Recommendation Report for Planning Permission for Works or Extension to a Dwelling

REF NO: M/2/21/HH

LOCATION: 45 Southdean Close
Middleton-On-Sea
PO22 7TH

PROPOSAL: Two storey front extension, first floor side extension, single storey side extension, two storey side extension, conversion of roofspace to habitable use with rear dormer and installation of 4 x balconies.

Revisions:

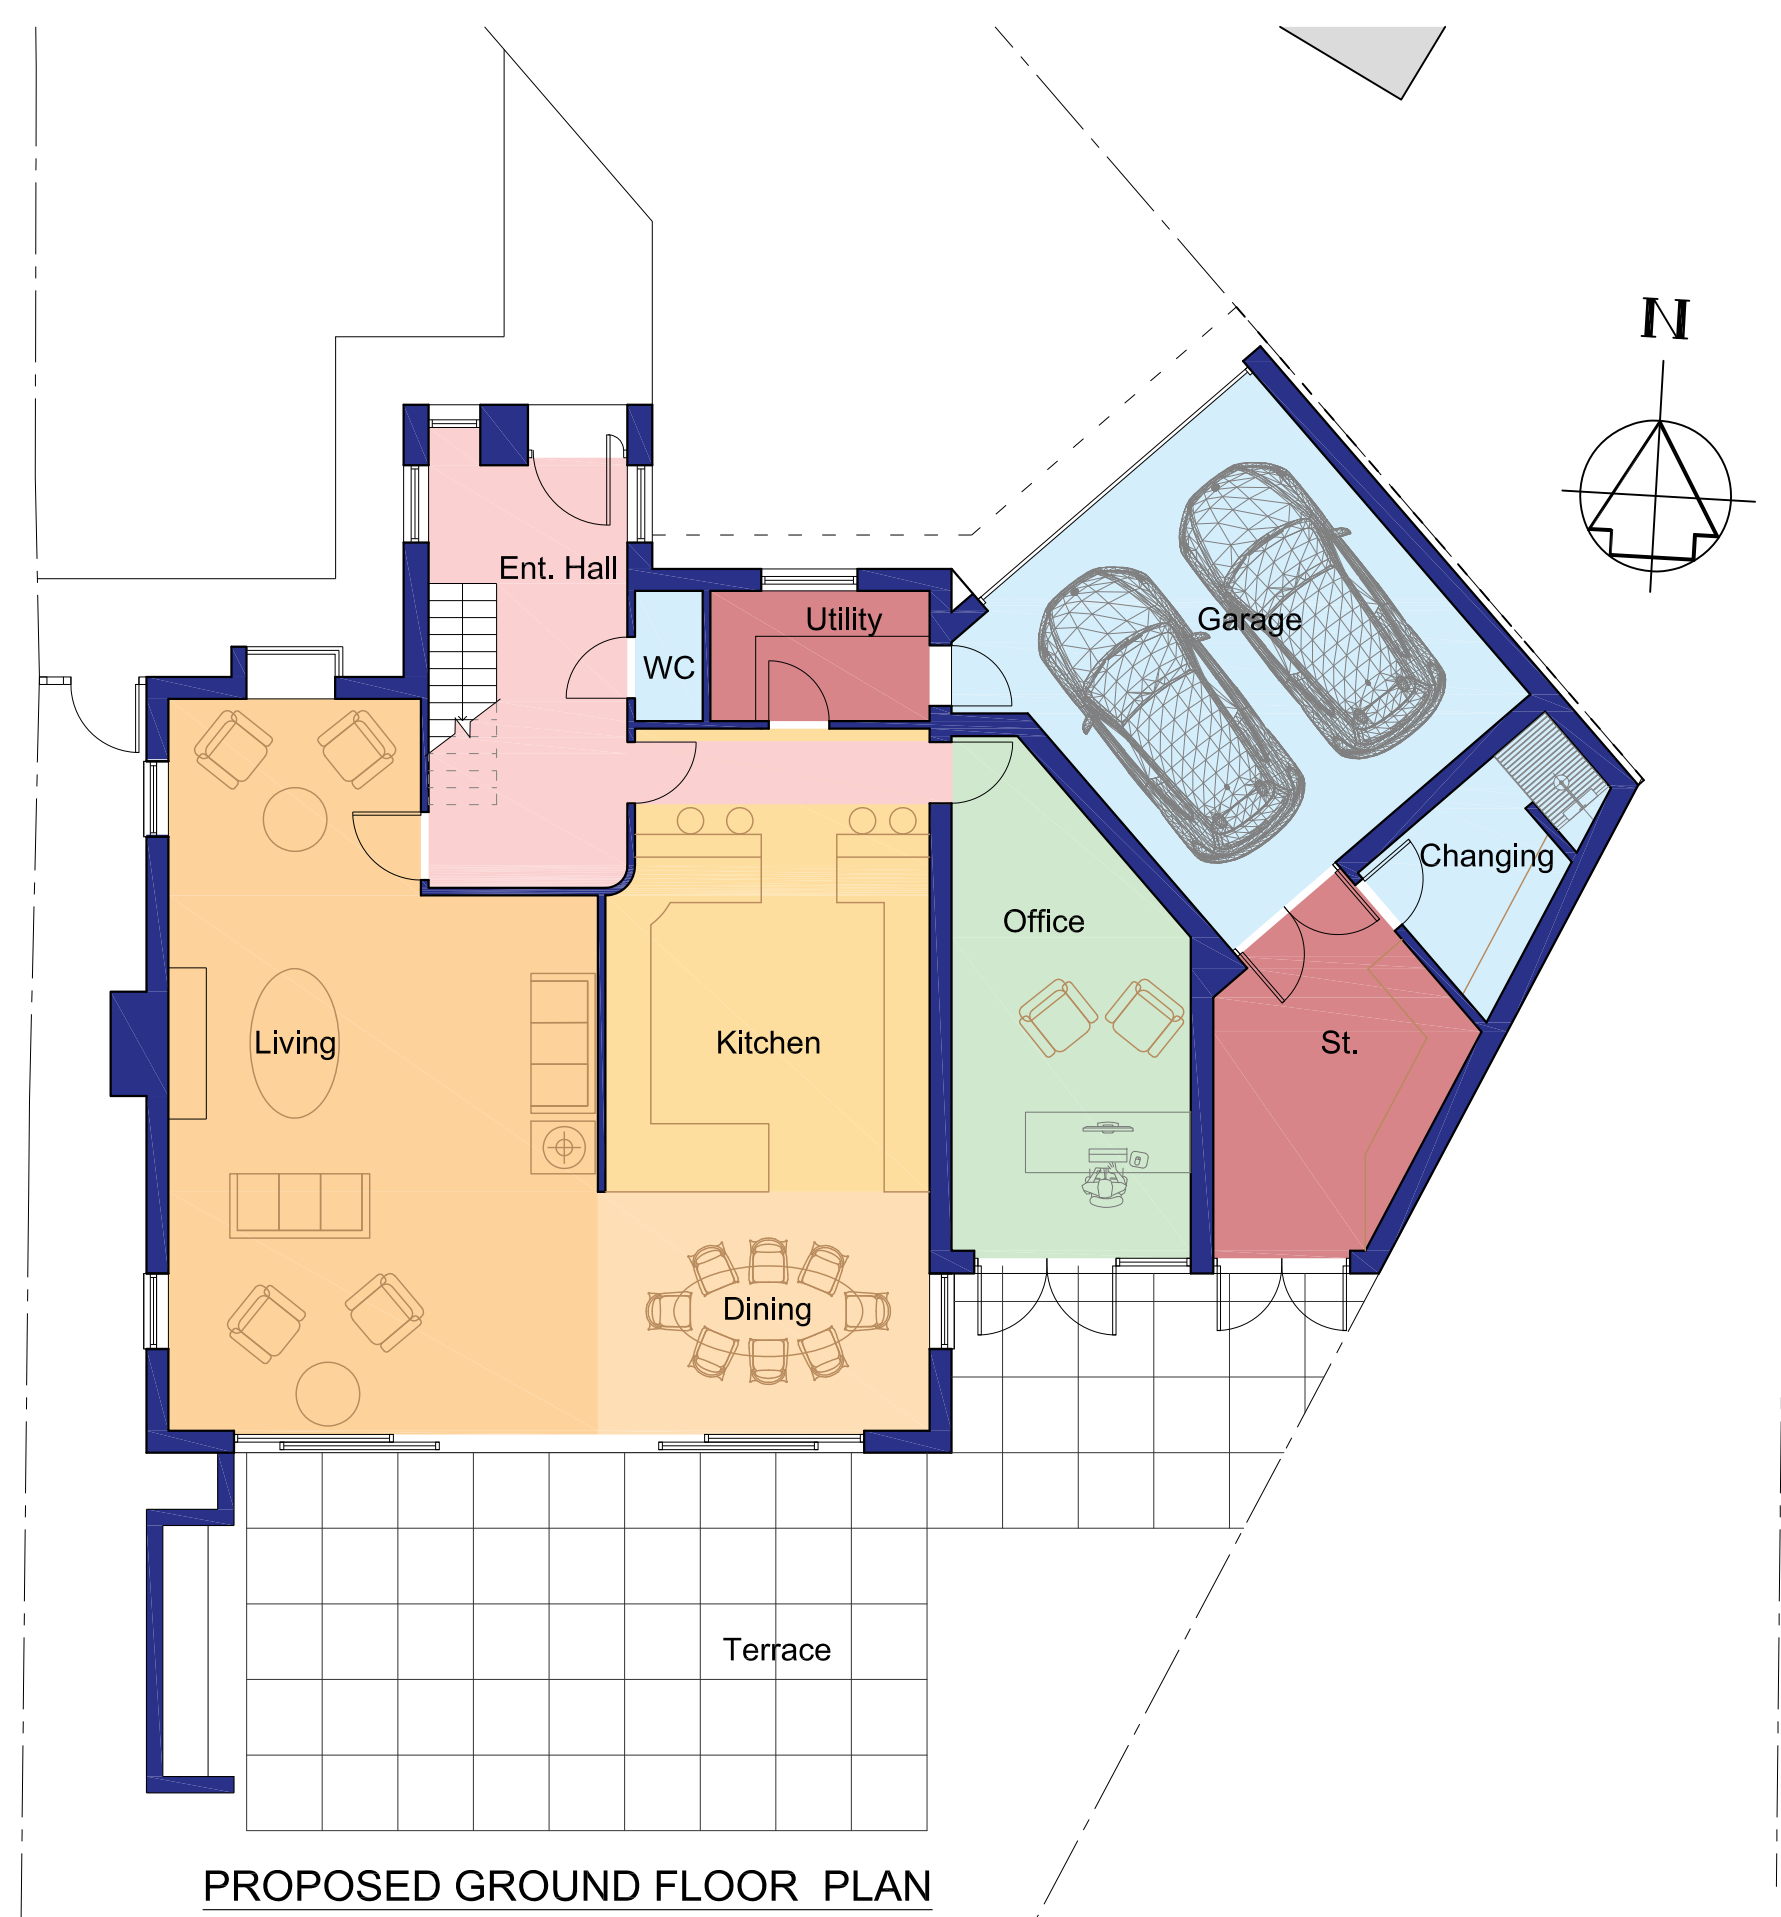
At the side elevations the proposal is for a first floor side extension, single storey side extension and two storey side extension. The proposal at the side (east) on these elevations will result in significant harm to the neighbour at the side, 1 The Jetty. This is due to the first floor extension with the addition of bedroom 4, the extension will result in sunlight being blocked to the private amenity space of 1 The Jetty, therefore having a harmful impact on this neighbour.

The balcony which leads out onto bedroom four will result in overlooking and overbearing effects to the 1 The Jetty to the east. This is due to the balcony being positioned on a first floor extension which looks out onto the rear garden on this neighbour. As a result, causing significant overlooking effects which results in this application being refused.

- 1 The extension due to its scale, design and close proximity to the boundary will have an oppressive and unneighbourly effect on neighbouring occupiers contrary to policies D DM1 and D DM4 of the Arun Local Plan.
